Application Ref:	2026/0197			 Ribble Valley Borough Council www.ribblevalley.gov.uk
Date Inspected:	08/05/2026	Site Notice:	08/05/2026	
Officer:	EP			
DELEGATED ITEM FILE REPORT:				REFUSAL

Development Description:	Proposed demolition of existing agricultural building and the erection of a new agricultural storage building.
Site Address/Location:	Holkers Farm Whins Lane Read BB12 7RB

Title: Existing Site Plan

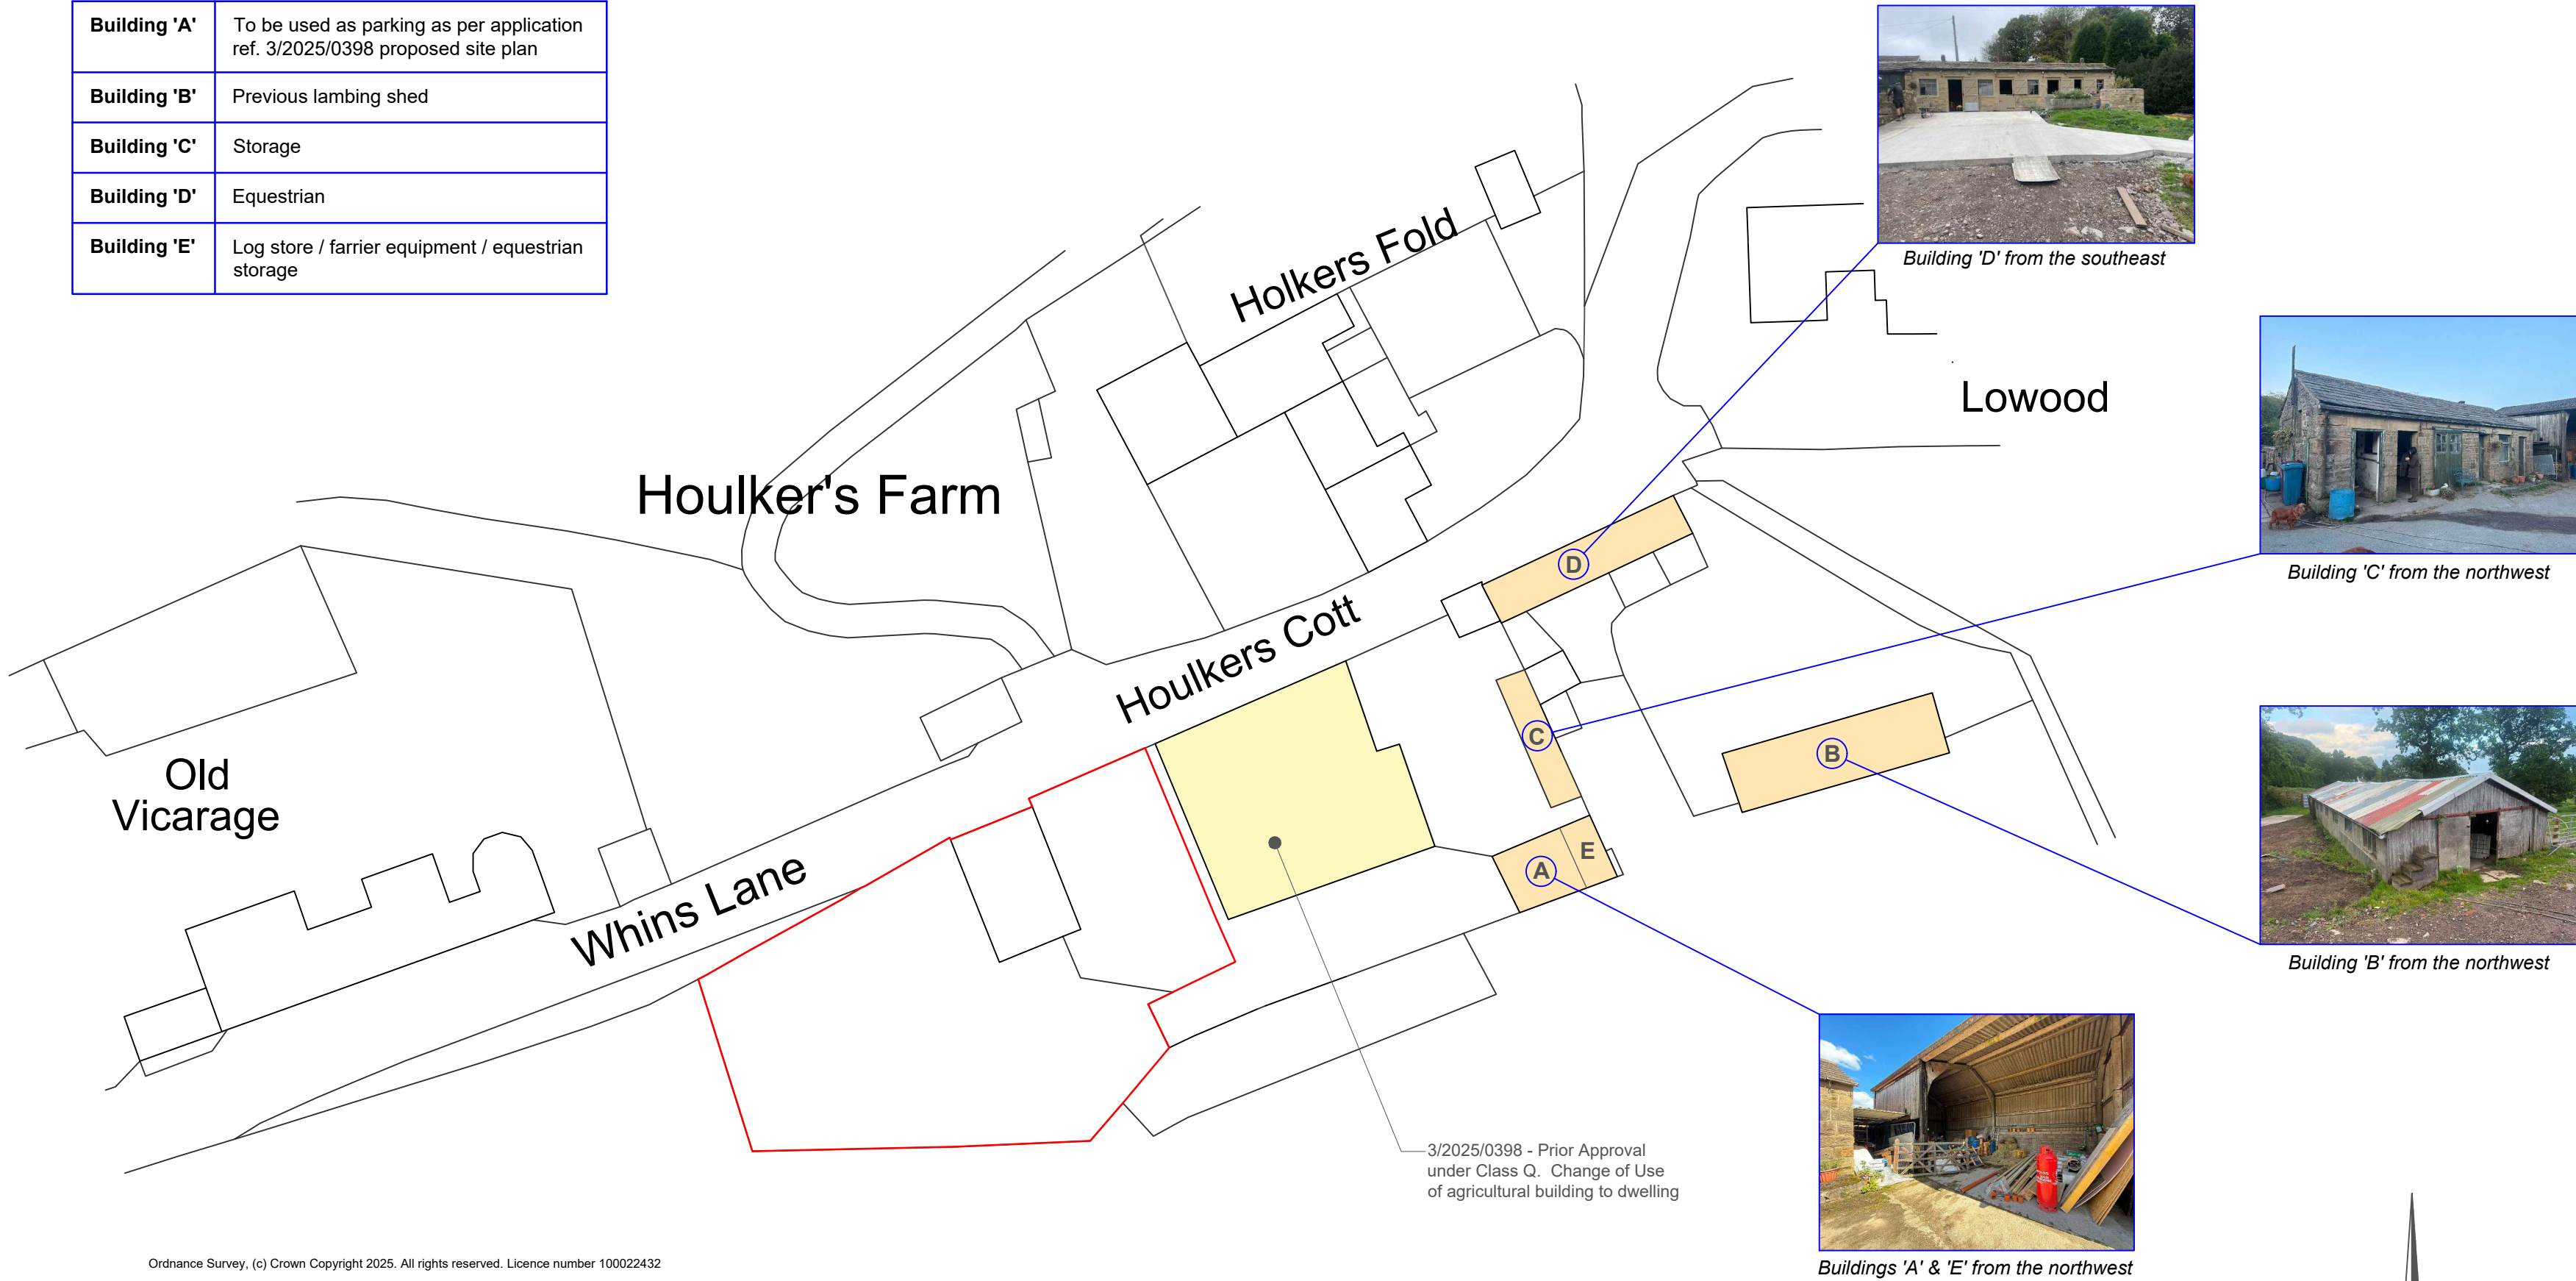
The adjacent land parcel is just 7.5 hectares in area which a relatively small land parcel. It is also worth noting there are approximately 4 other buildings within the applicant's ownership adjacent to the application site. It is not clear from the submitted information why the existing buildings, particularly building B on the supporting site plan, are not fit for such storage purposes, either in full or part.

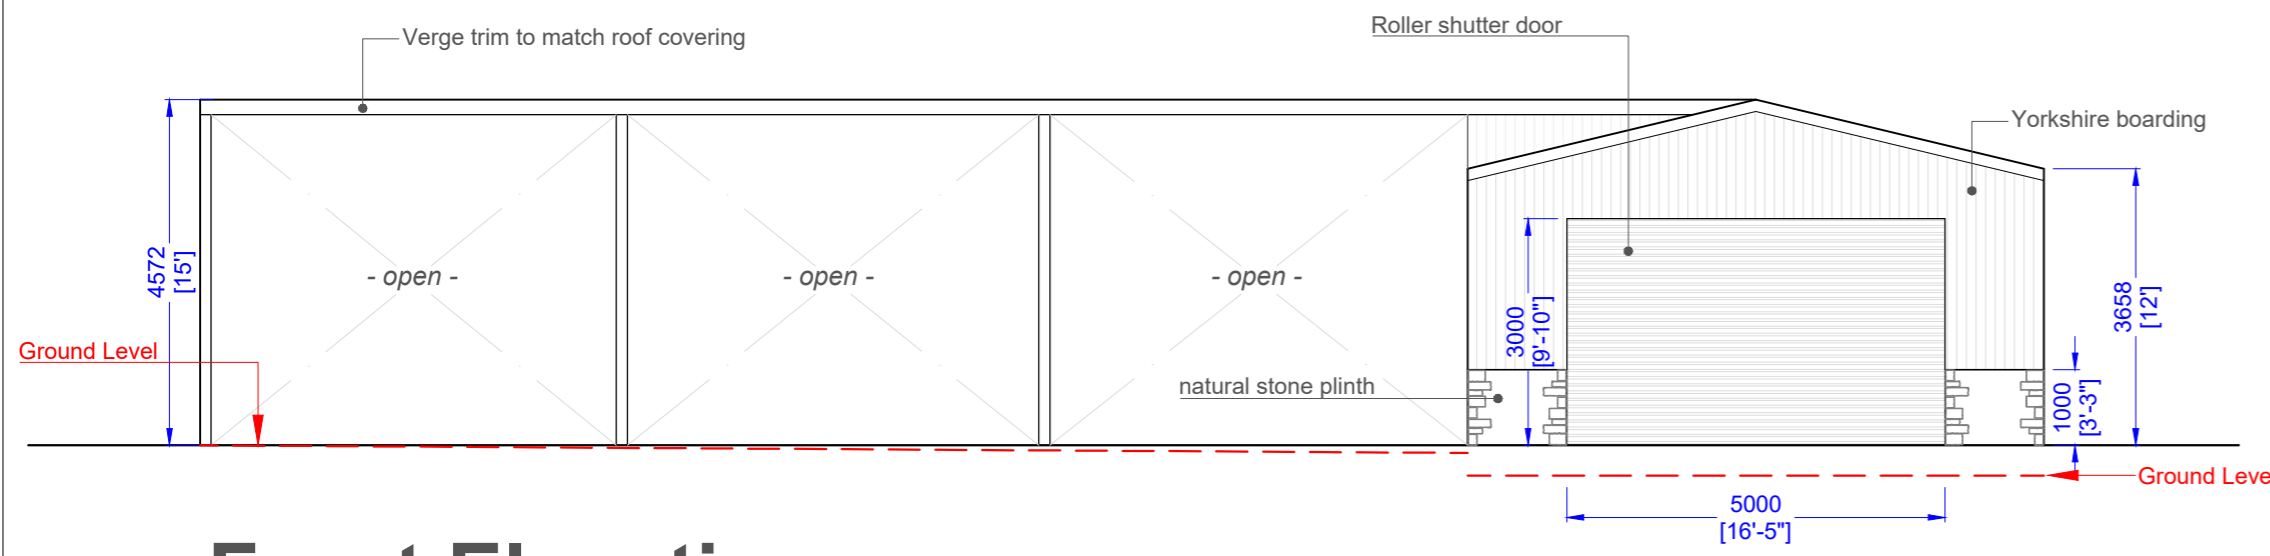
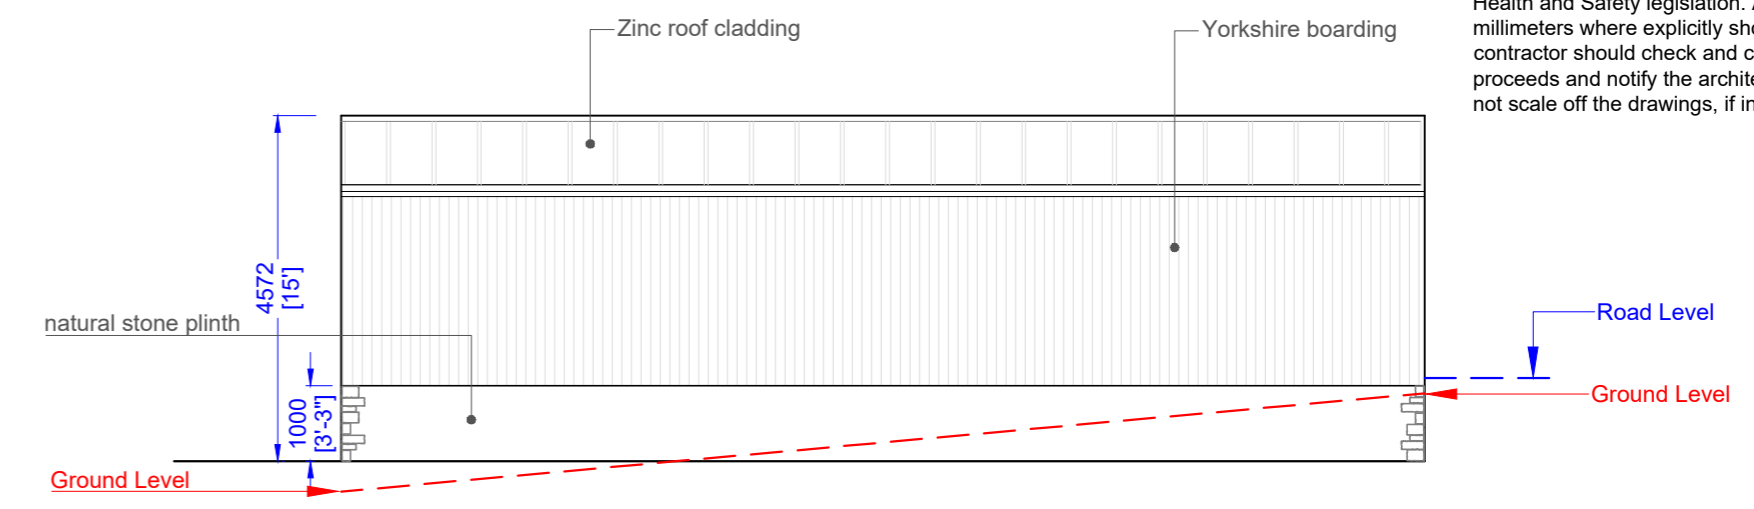
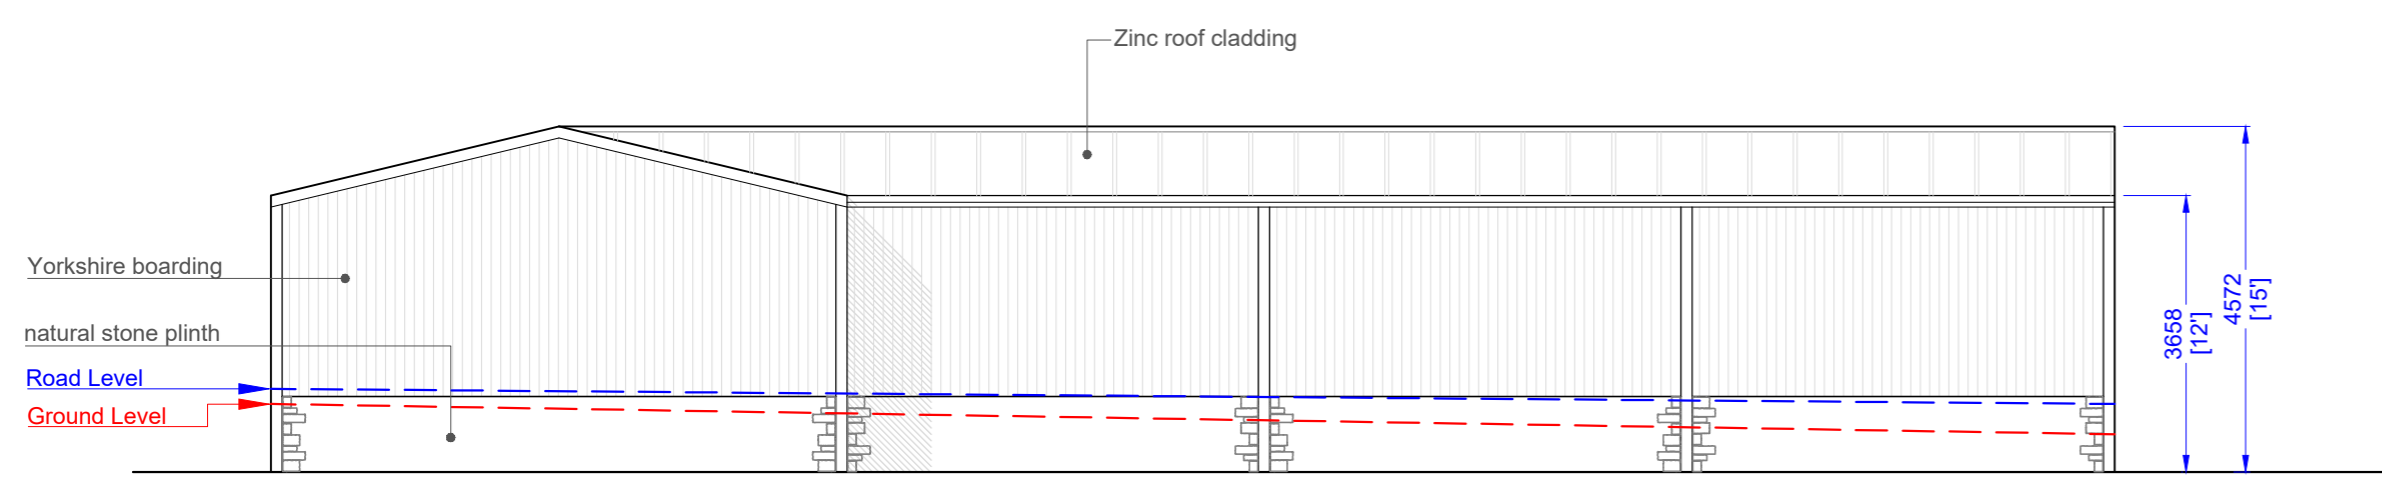
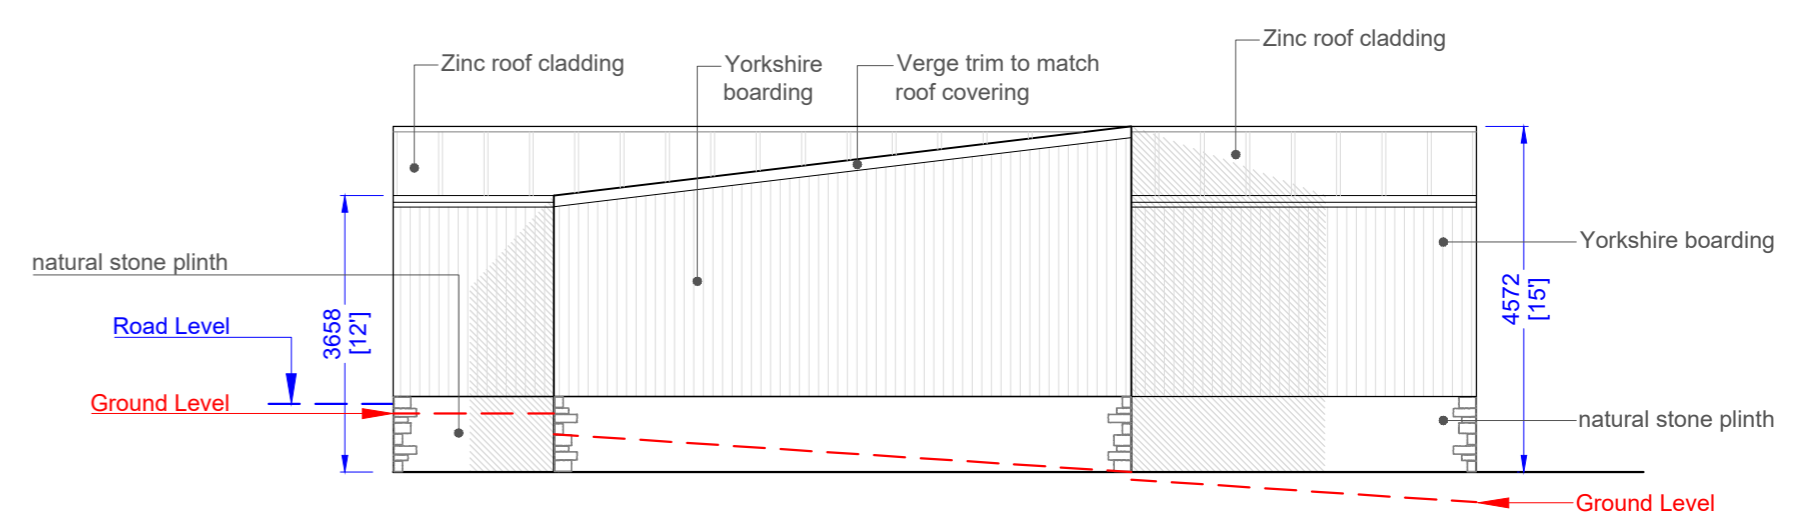
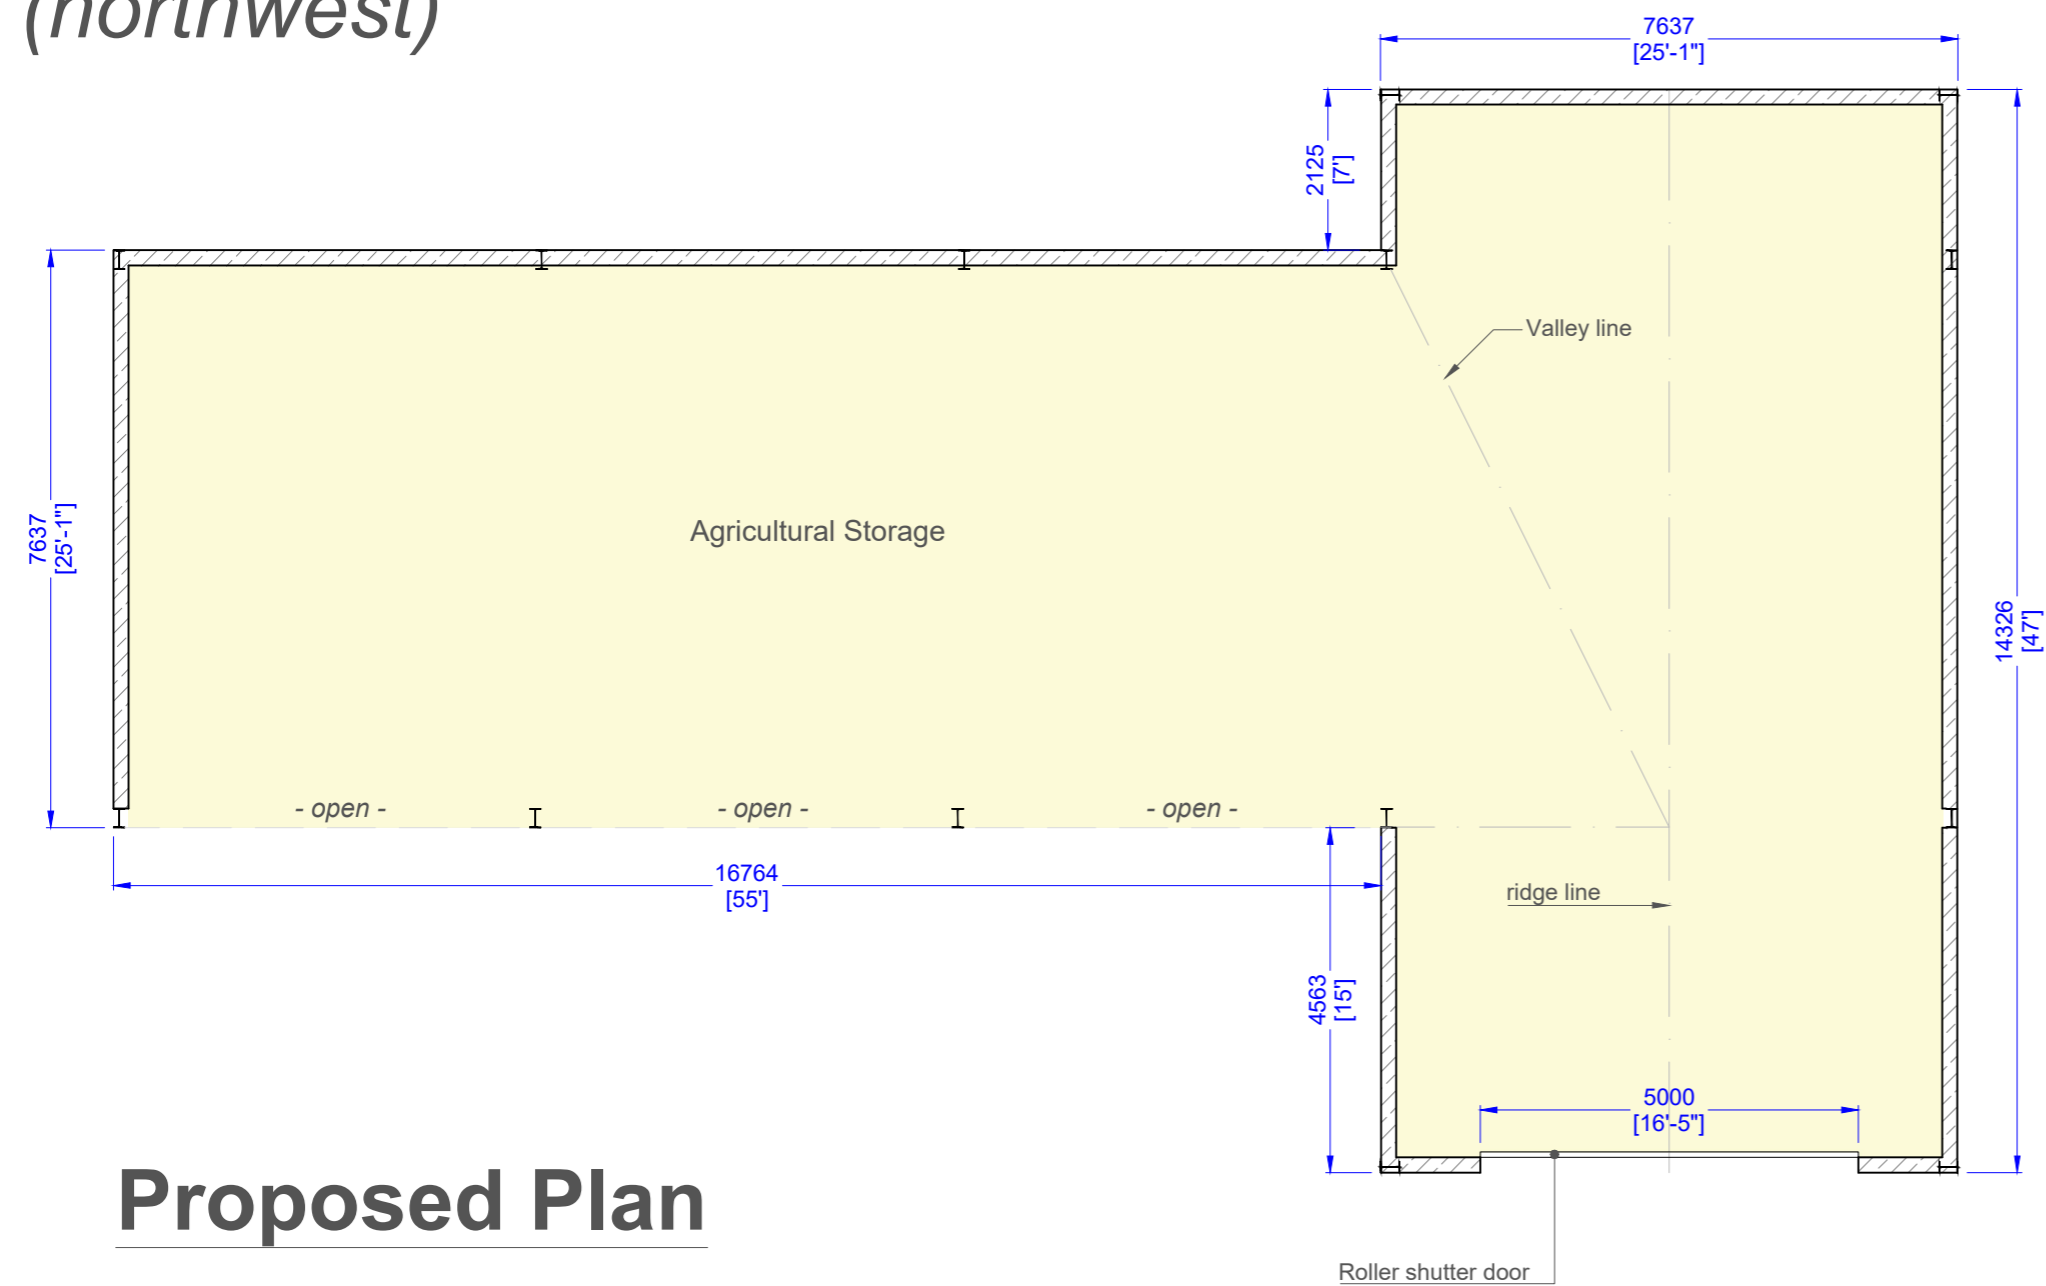
The proposed building is to be constructed using Yorkshire boarding, with a natural stone plinth and a zinc cladded roof profile. The building will also be partially open sided to one side with roller shutter doors proposed to the other. Overall, largely by virtue of the roller shutter doors, the building has an industrial appearance that would appear anomalous and incongruous within the street scene of harm to the inherent character of the area.

Furthermore, the proposed building is substantial in scale measuring 24.4m by 14.3m (at its widest points) and comprising a 'T' shaped configuration. Given the siting of the building adjacent to the highway, paired with the substantial scale, the building would take a dominant position within the street scene detracting from the character of the adjacent barn and wider streetscene. As referenced earlier in the report, it is not considered that there is reasonable justification for a building of this scale, taking into consideration the size of the land parcel and associated farming operations.

The proposed building, by virtue of its scale, siting and industrial design would result in the introduction of an anomalous and dominant development within the street scene of harm to the character of the area and contrary to Policies DMG1 and DMG2 of the Ribble Valley Core Strategy and Paragraph 135 of the NPPF.
